Case Reference: PAX92.324370

Re: Proposed Littleton Wind Farm, County Tipperary

Formal Objection to Proposed Development

Viewpoint locations selected for the Littleton Wind Farm project

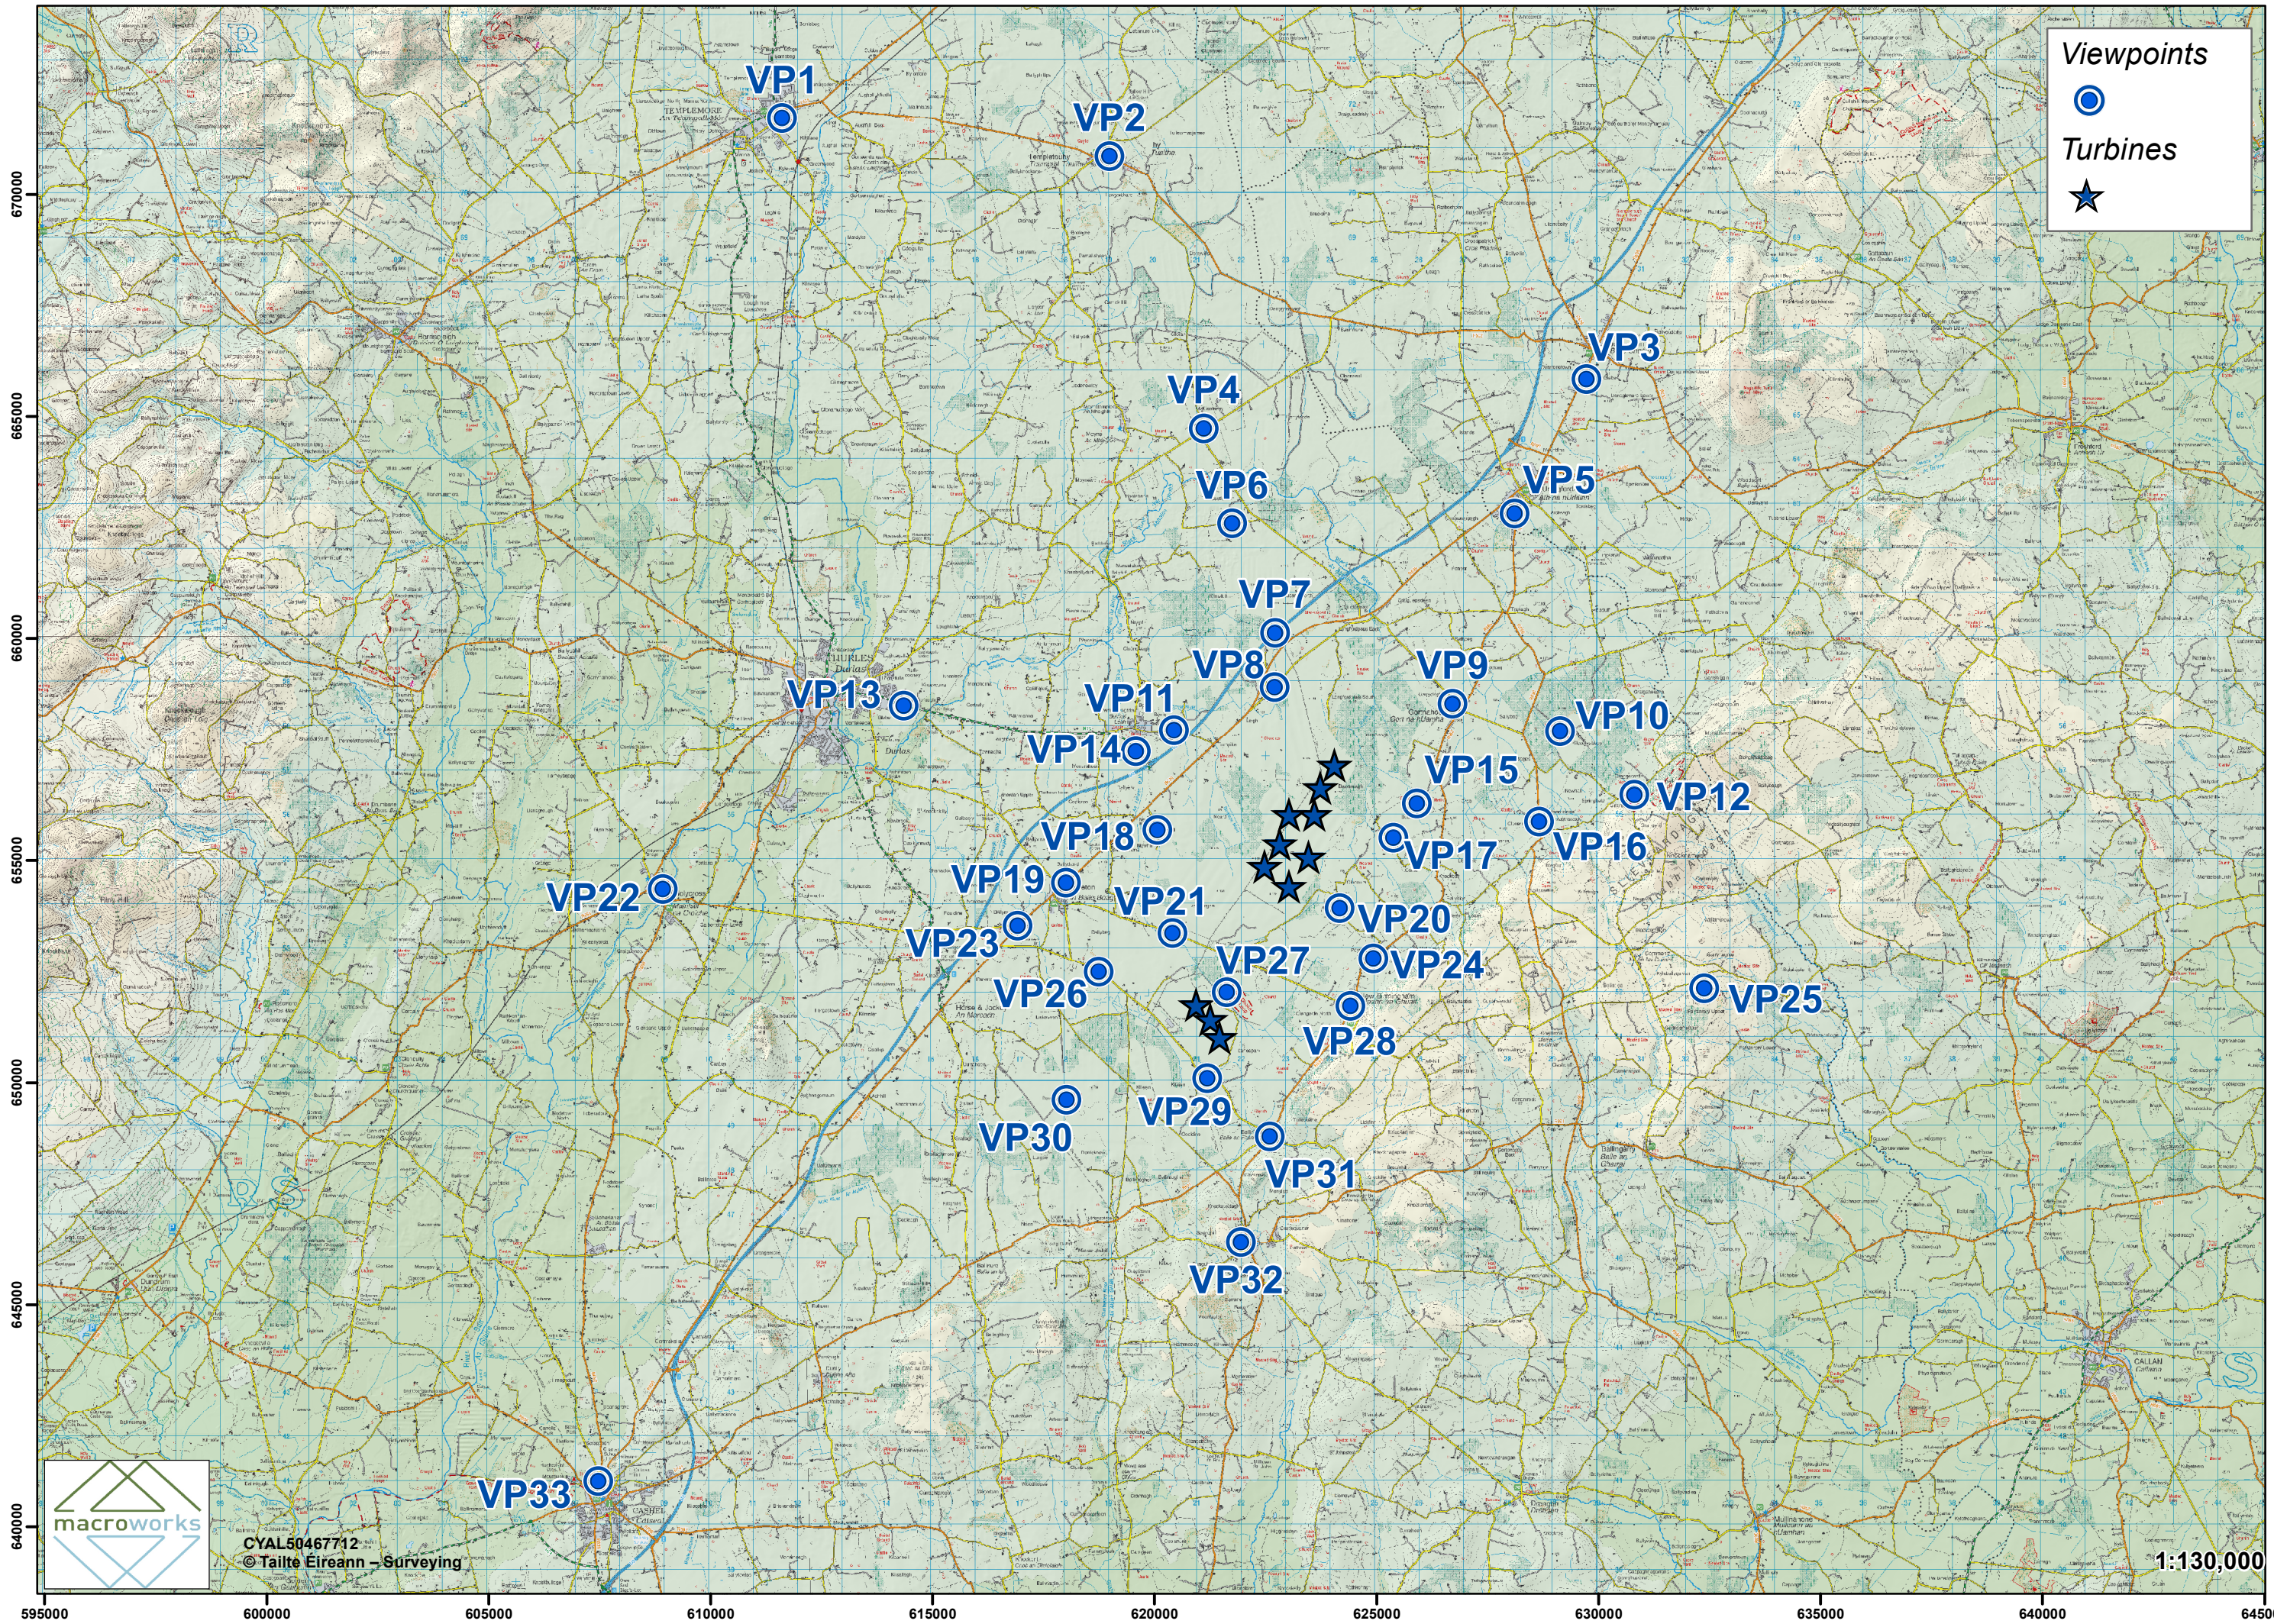
The applicant's **VP20 viewpoint at Poyntstown** is approximately 1.3 km from T8.

The applicant assesses the visual impact magnitude at this viewpoint as **High-Medium**, with a **Substantial-Moderate, negative and long-term visual effect**.

The applicant's **VP21 viewpoint at Derryhogan** is approximately 1.7 km from T9.

The applicant assesses VP21 as having a **Moderate, negative and long-term visual effect**.

At VP21, substantial vegetation exists between the viewpoint and the turbines, yet the upper portions of the turbines remain clearly visible.

<b>TITLE:</b>	Windfarms within 20km
<b>PROJECT:</b>	Littleton Windfarm
<b>FIGURE NO.:</b>	4.6
<b>CLIENT:</b>	Littleton Wind Farm DAC
<b>SCALE:</b> 1:200,000	<b>REVISION:</b> 0
<b>DATE:</b> 30/04/2026	<b>PAGE SIZE:</b> A3

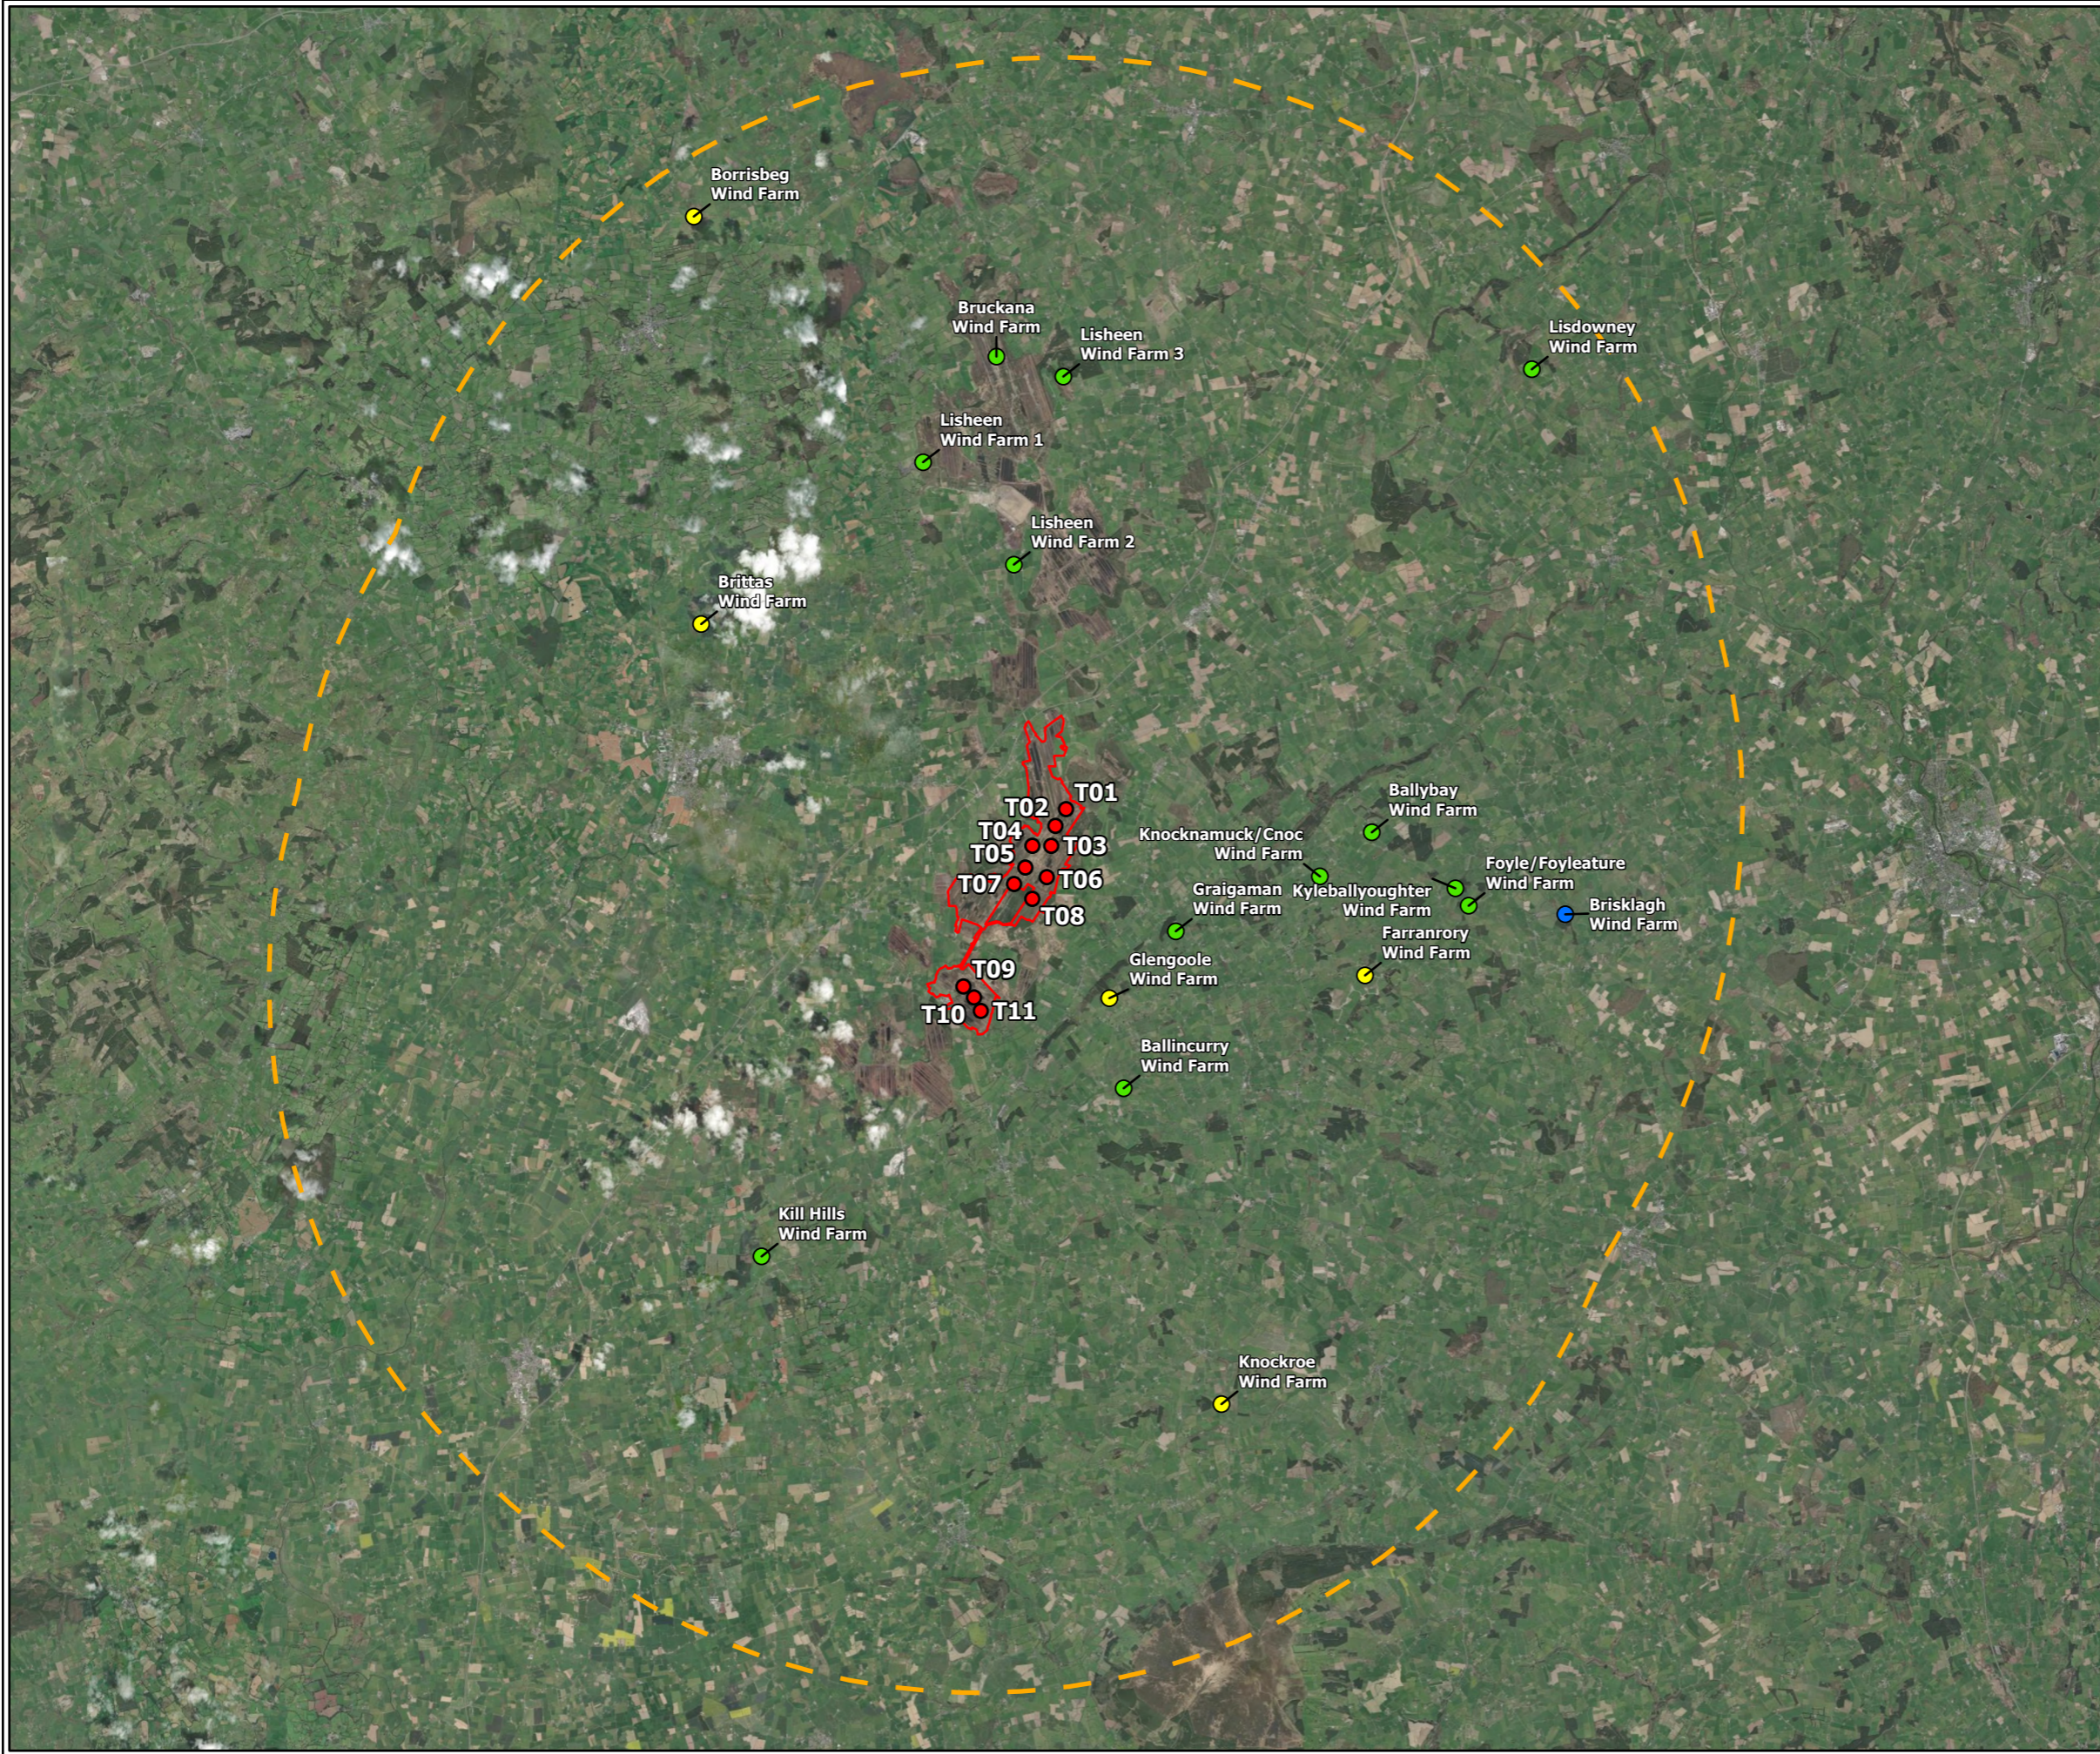
The applicant identifies approximately **128 existing and consented turbines within 20 km** of the proposed development.

The proposed 11 turbines should therefore not be assessed as though they were being introduced into an otherwise undeveloped landscape.

The Board should consider the cumulative effect of:
